Planning Application Reference No.: 3/2025/0363

Address of Development: Land off Pendle Street East Sabden BB7 9EQ

With regards to the above planning application (3/2025/0363), I wish to raise my objection based on the following points:

Drawing file: planx_downloads / 25_0363_Boundary_Treatment_Details.pdf

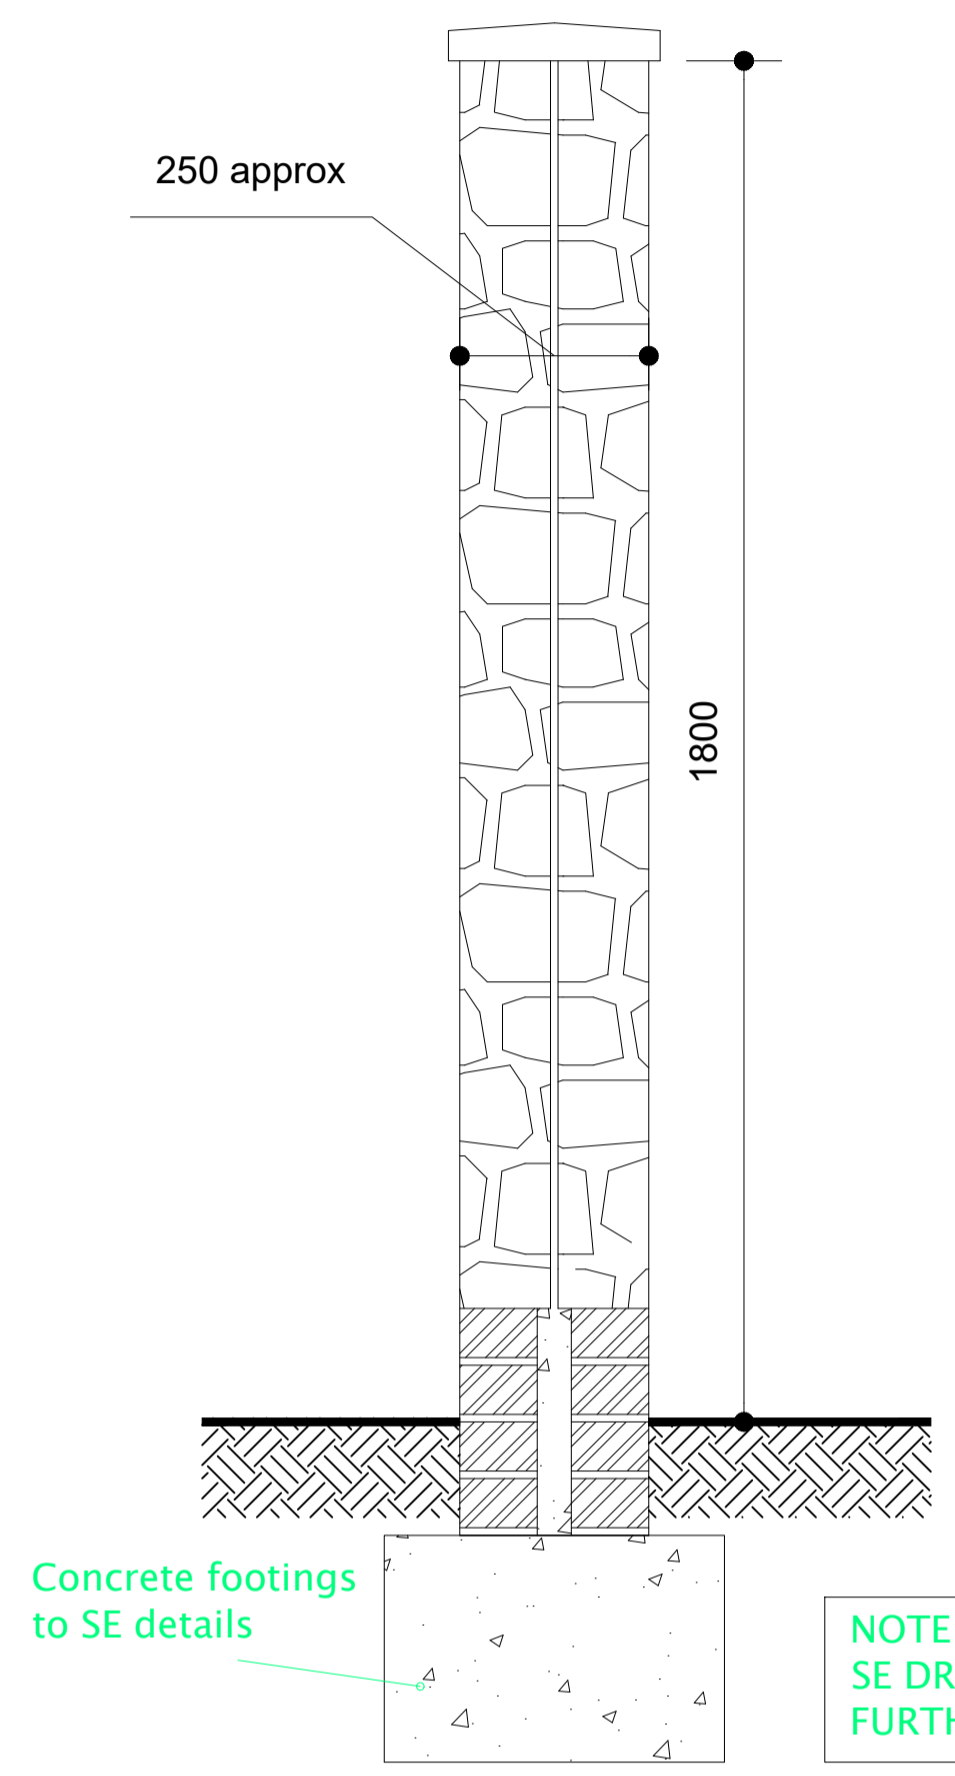
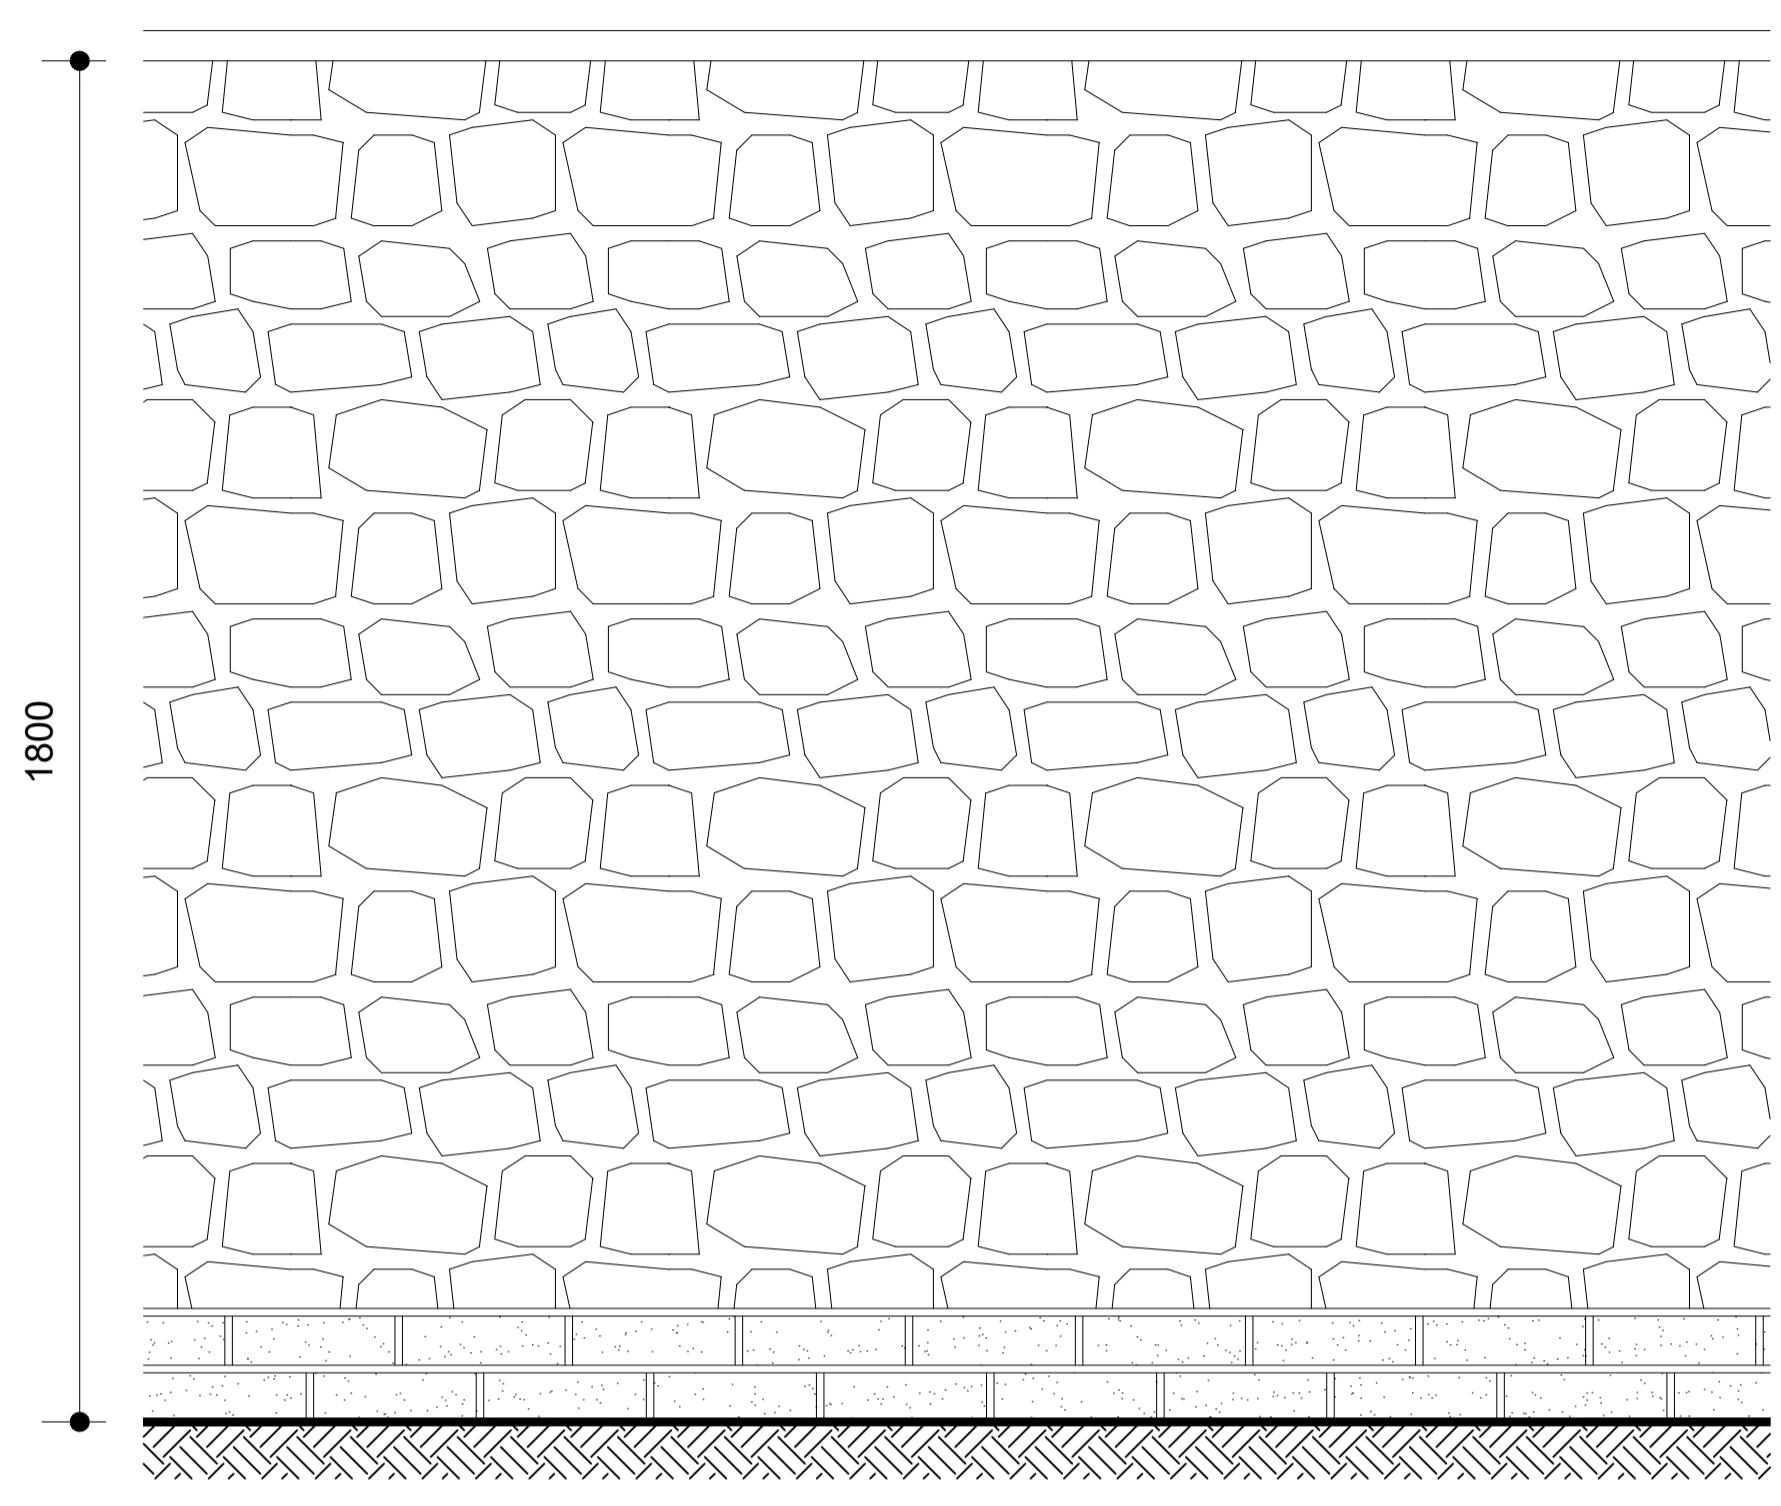
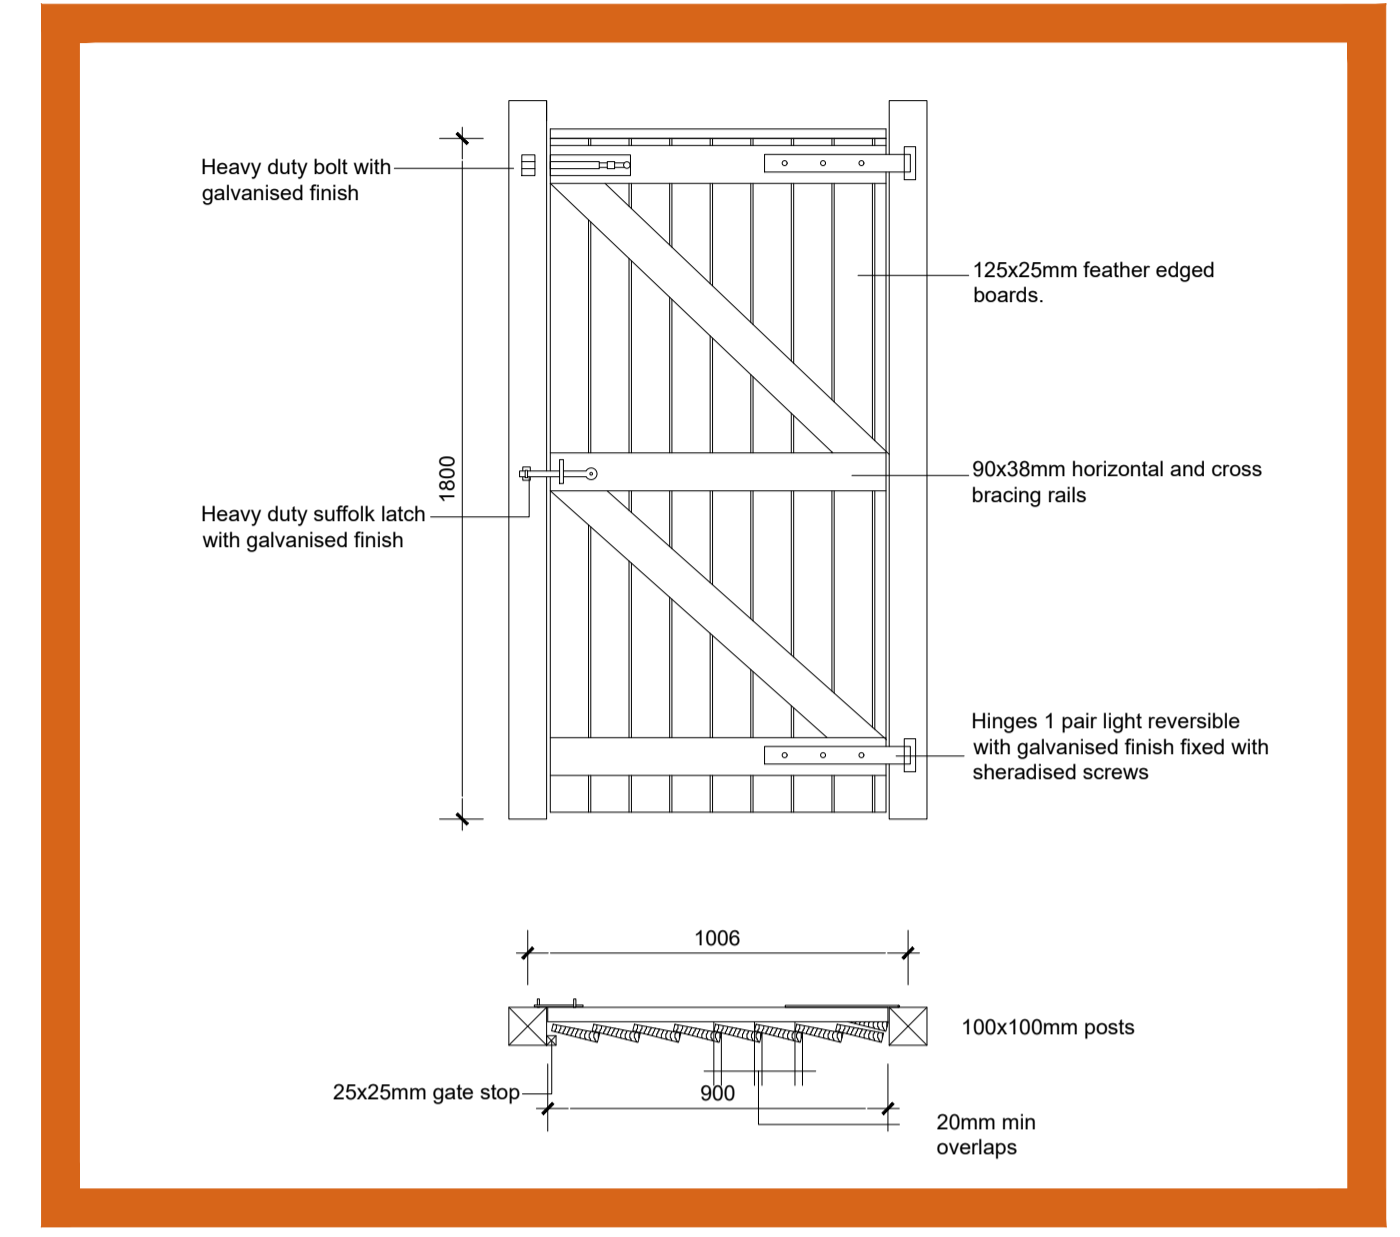
6. The suggested boundary walling in artificial stone is completely wrong for this setting. Walling of this type is not seen anywhere in the village to my knowledge and is both out of place and out of character for this small rural location. Even the nearby mediocre Cobden Close development uses real stone boundary walls. Such poorly considered boundary walling will jar, separate, and segregate the occupants of the proposed development rather than integrating them into a close-knit village community. The developers should look at the recent Skipton Properties/Victoria Mill development to see how to successfully integrate a new development into a rural village.
